**Our Case Number:** ABP-314501-22

**An  
Bord  
Pleanála**

**Date:** 13 February 2023

**Re:** South Dublin Street and Backlands Regeneration Project. The proposed development covers an area of approximately 2.72 hectares and comprises urban regeneration and public realm proposals. Properties at 7- 13 Dublin Street, lands to the rear of 1-9 The Diamond and 1-26 Dublin Street, the Courthouse car park, Lower Courthouse car park, Castle Road, and N54 Macartan (Broad) Road, townlands of Roosky and Tirkeenan, Co. Monaghan

EXISTING BUILDINGS TO BE DEMOLISHED
Dublin Street No. 08, 09, 10 and 11.

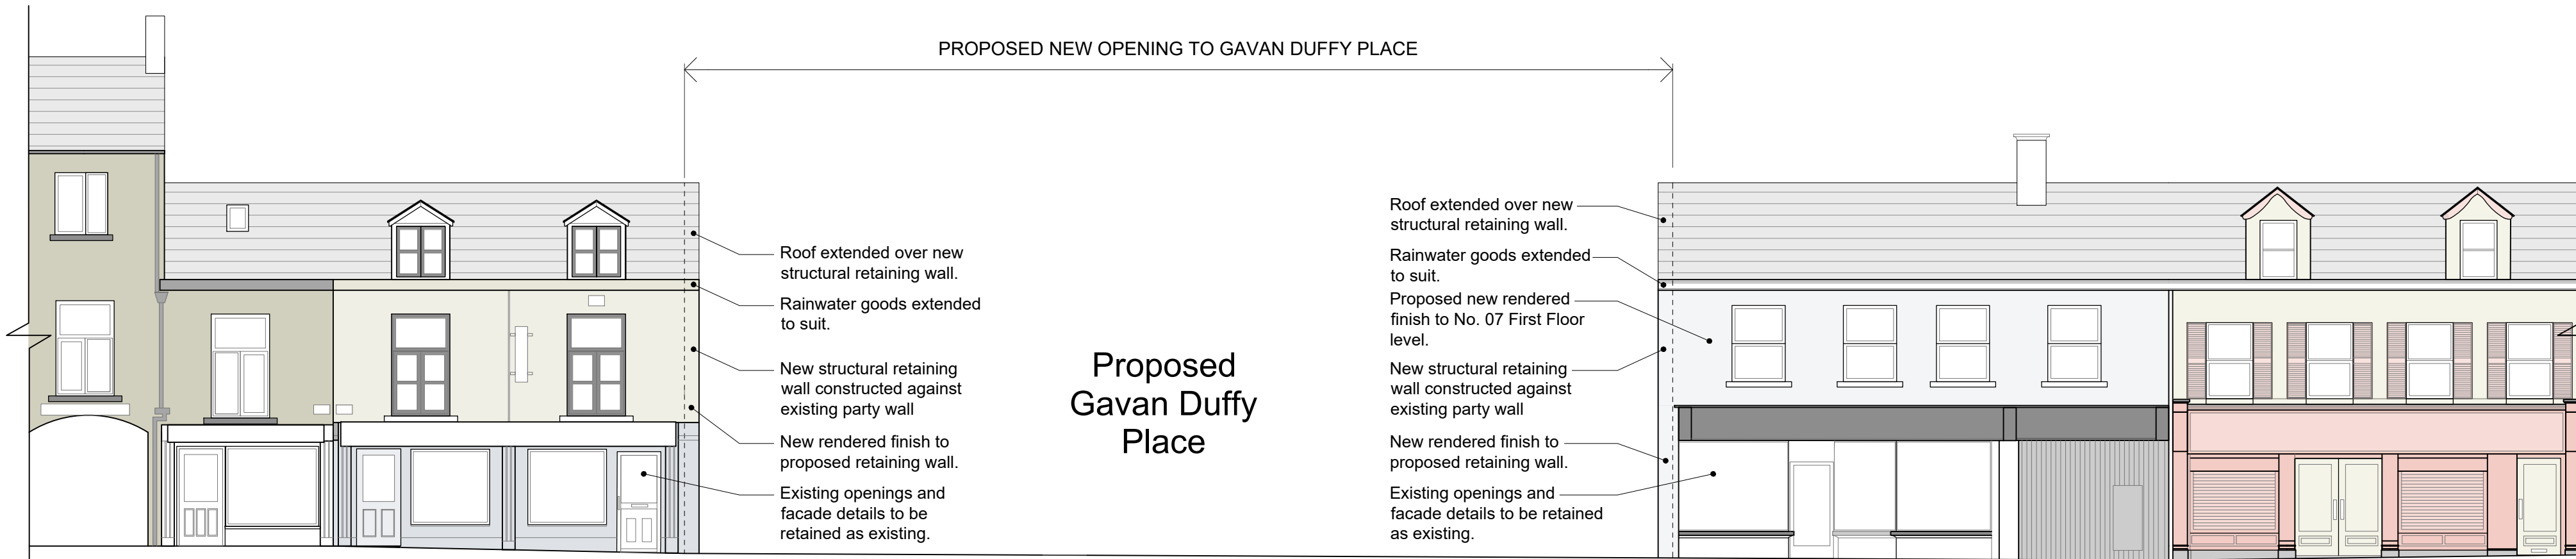
The proposed development involves the demolition of a number of buildings comprising established street frontage and an outbuilding within the curtilage of an adjoining protected structure, and the creation of a new vehicular street together with significant surface car parking.

The aforementioned recent national policies, the concerns that the proposal is a "modern car-focused proposal", the proposed demolition of part of the streetscape opposite a group of structures within the Dublin Street ACA, the cultural significance of one of the buildings to be demolished and the lack of justification for the vehicular connection to Dublin Street, when taken in totality, suggest that an alternative proposal for enhanced pedestrian access *only* may be warranted.

The applicant is therefore invited to reconsider the proposed scheme and following consultation with the Department of Housing, Local Government and Heritage, submit a response to the concerns raised, including revised drawings as may be necessary.

Figure
5.1

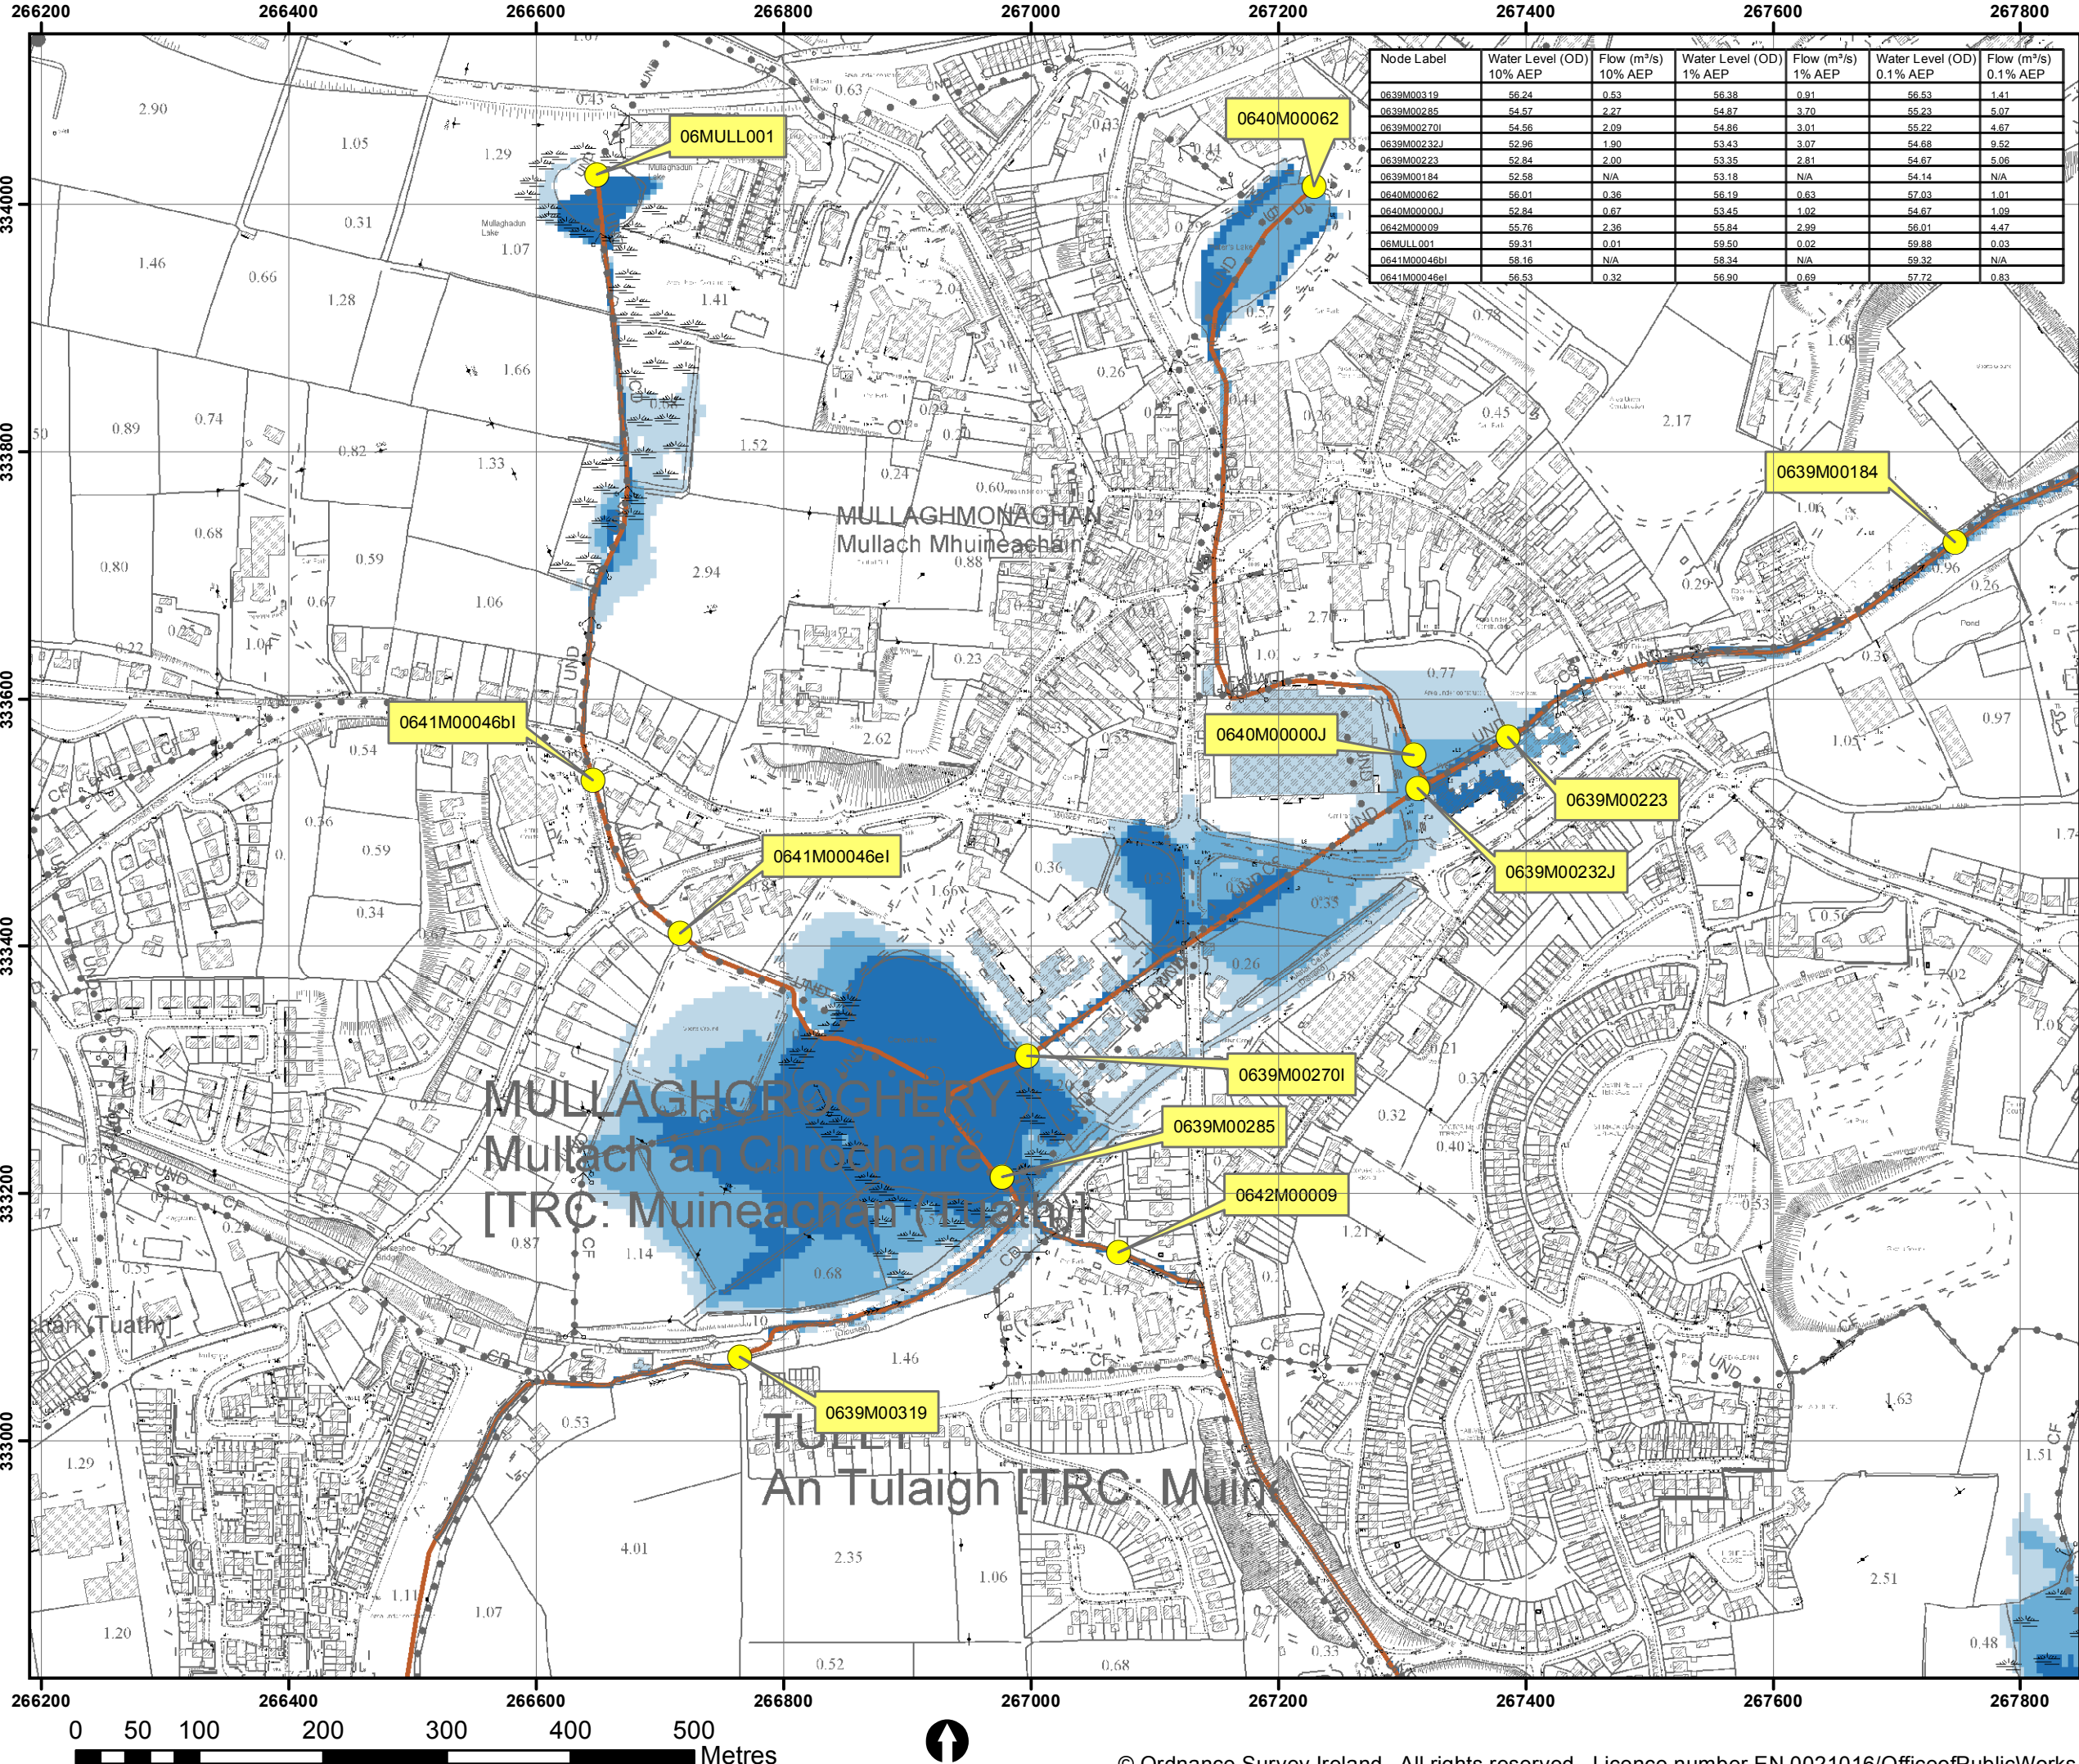
Following a review of Chapter 5 – Flood Risk and Drainage of the EIAR, the Flood Risk Management Plan for Neagh Bann (2018) and associated OPW data, it appears that the significant flood event of 2011 was a result of a blocked culvert, which is prone to blockage, and is proximate to the site. Furthermore, while funding was approved in 2019 to construct a new culvert across the N54 and the R162 in Monaghan Town and additional flood alleviation measures for the Castle Road area it appears that such works have not been undertaken, having regard to section 5.4.2.1 of the EIAR. Please expand and clarify this issue.
